Peer review of Alternative Natural Ventilation – Building 2

Peer review of Alternative Natural Ventilation – Building 4

Figure 1: Updated convergence graph

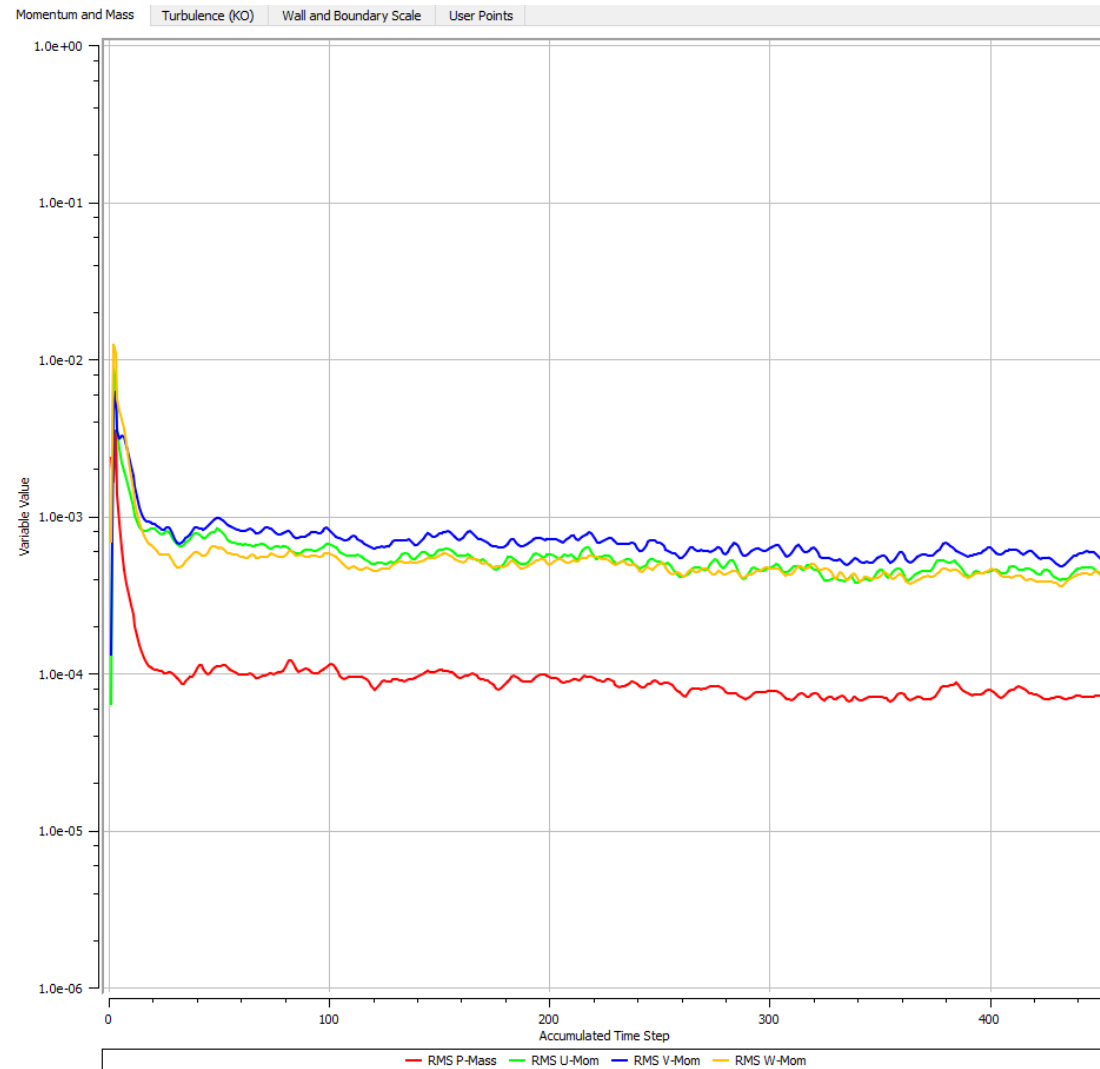
A convergence graph is shown for the key variable residual errors. The graph is presented at 300 iterations. It is assumed this is also the timestamp at which the results are taken. The graph shows some initial instability in the calculations, and we recommend additional iterations to confirm that the solution has converged.

A convergence graph is shown for the key variable residual errors. The graph is presented at 300 iterations. It is assumed this is also the timestamp at which the results are taken. The graph shows some initial instability in the calculations, and we recommend additional iterations to confirm that the solution has converged.

Figure 2: Velocity contour map – acoustic ventilator (in plan)

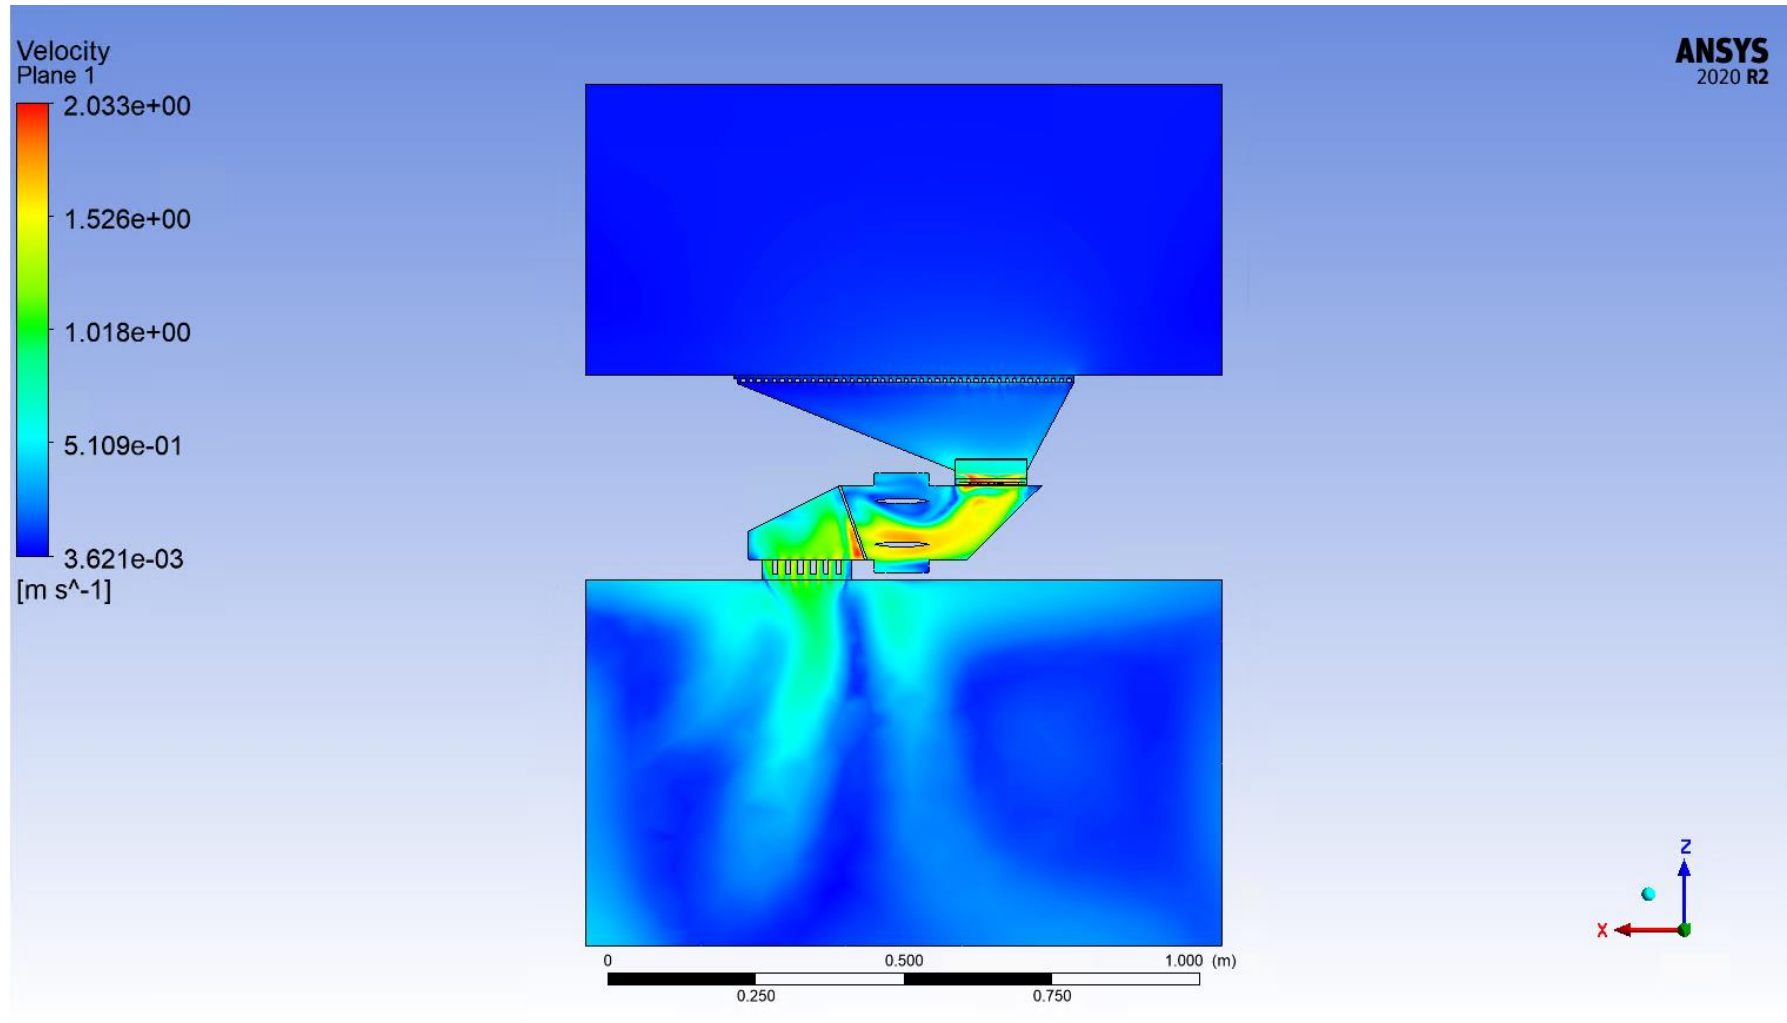
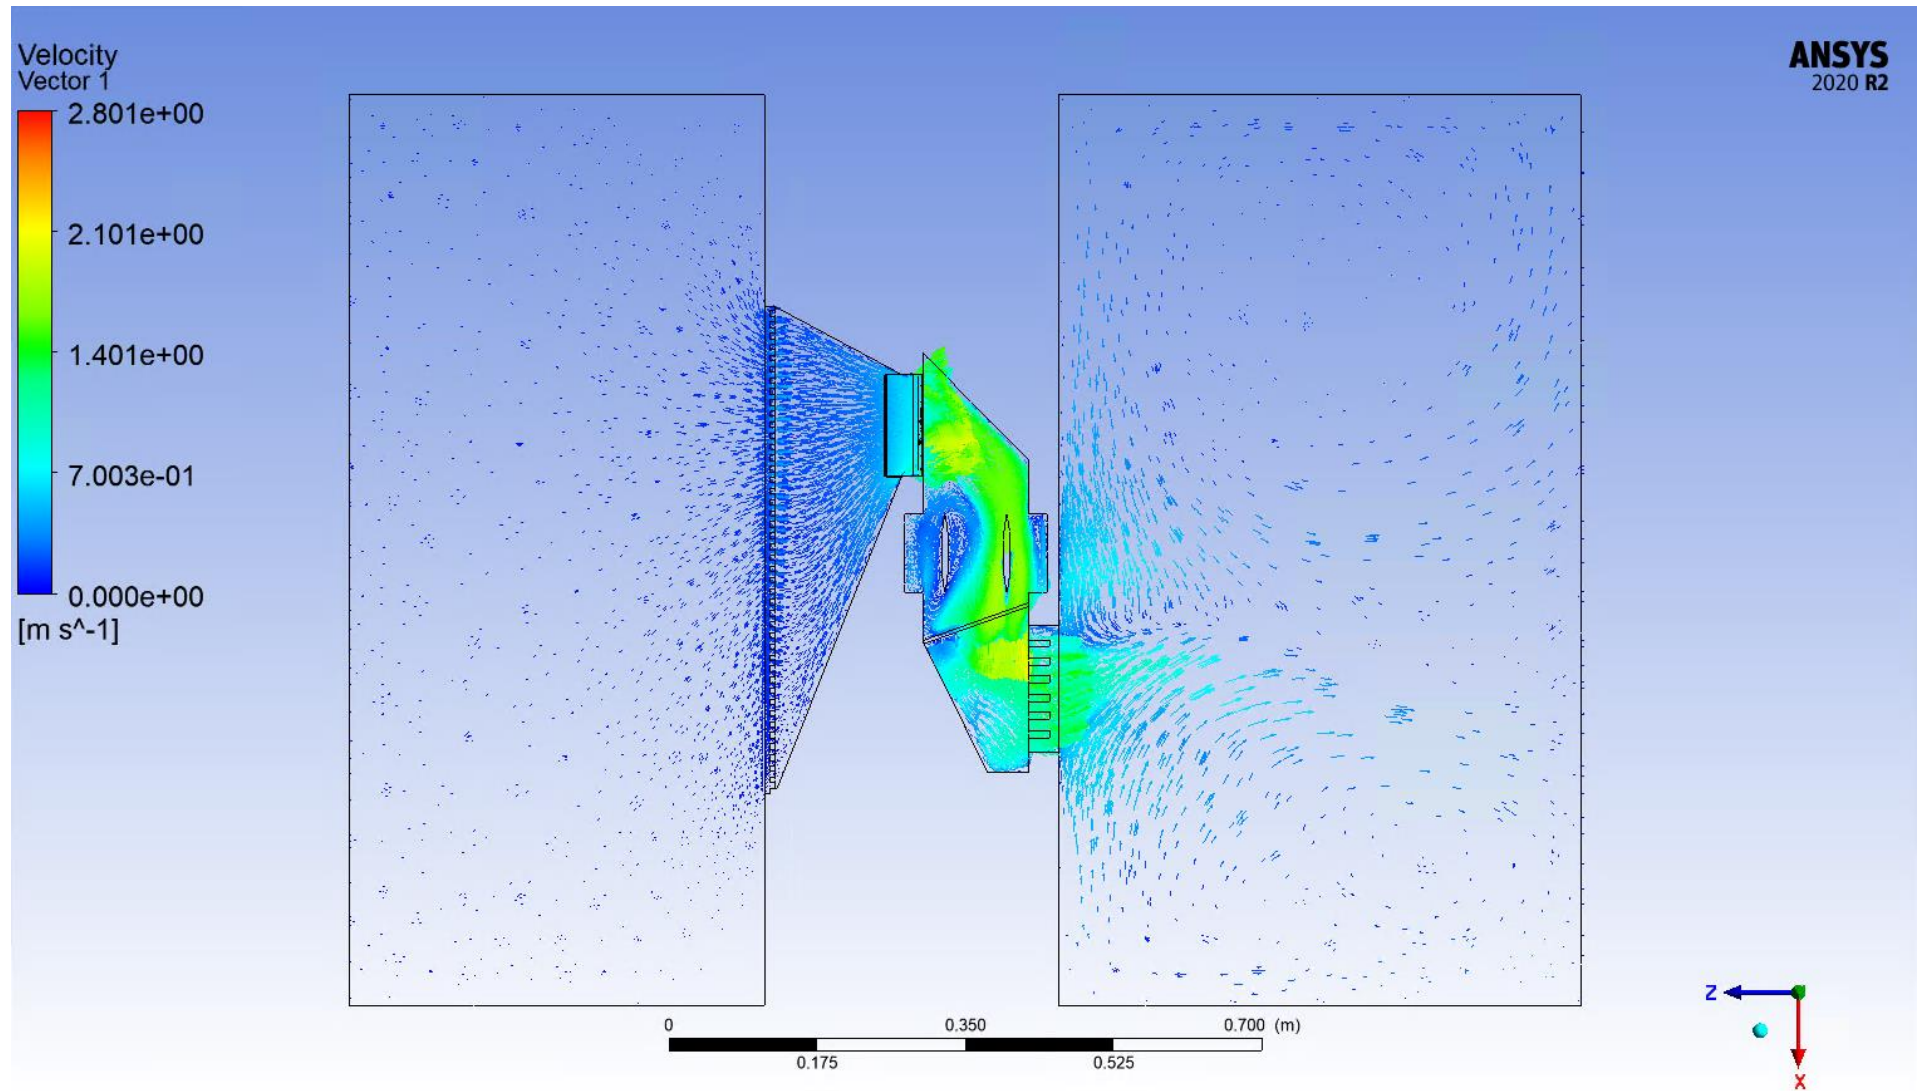
Results of the CFD calculations are shown for pressures but not airflows or velocity vectors. Airflow plots would add considerable weight and provide confidence to the results.

Results of the CFD calculations are shown for pressures but not airflows or velocity vectors. Airflow plots would add considerable weight and provide confidence to the results.
